## KITTITAS COUNTY COMMUNITY DEVELOPMENT SERVICES

RE: Kittitas County Public Works Sign Permit (SI-19-00001) - Deem Incomplete

**GENERAL**  
**SIGN ELEVATIONS & DETAILS**

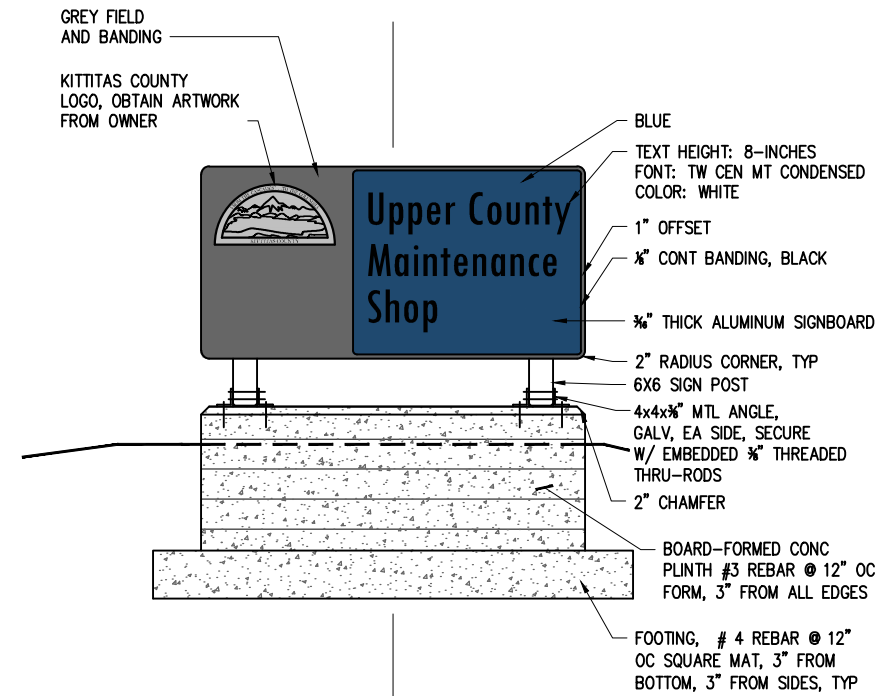
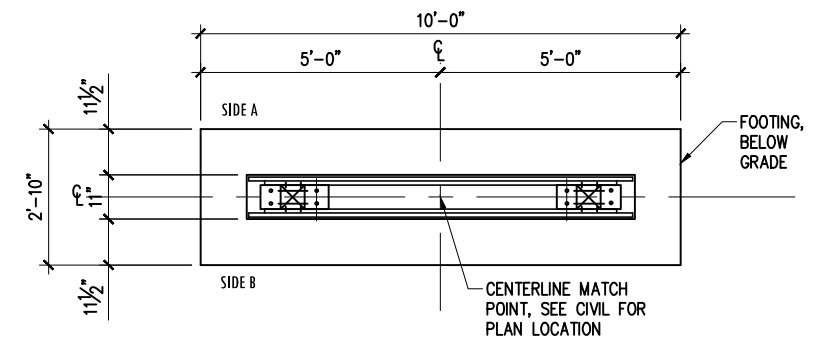
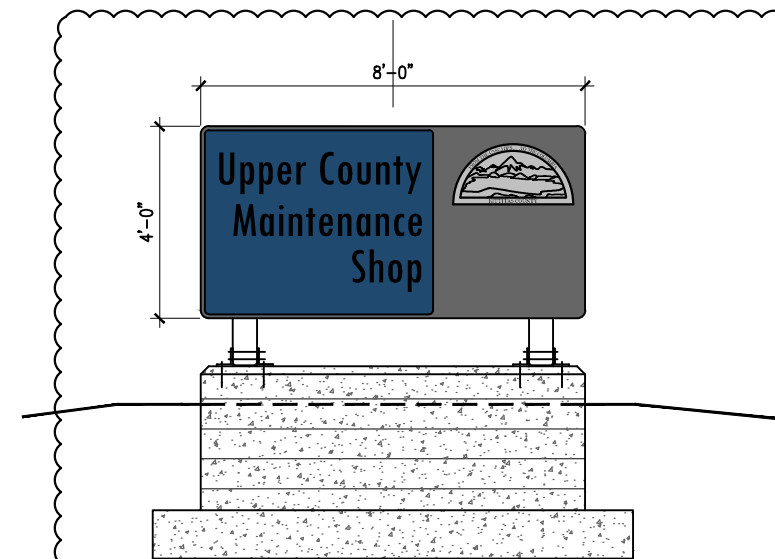
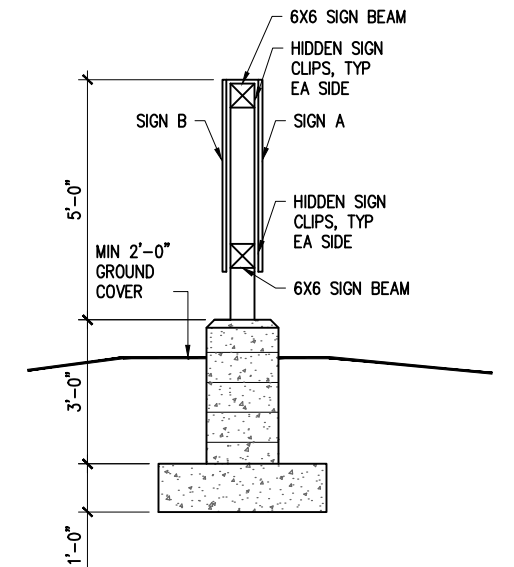
Upon preliminary review, the proposed wall sign on the face of the maintenance building appears to meet all criteria under Kittitas County Code (KCC) 17.70 Signs. However, the proposed monument sign near the entrance does not appear to meet the standards given in KCC 17.70.070(1)(b). Under this provision, monument signs are limited to “forty-two (42) inches above street grade when located within the sight triangle and not taller than seventy-two (72) inches above finished grade when located outside of the sight triangle”. As proposed, the sign is at least eight (8) feet from grade to the top of the sign. In order to continue processing, the monument sign must be redesigned to meet this provision of KCC.
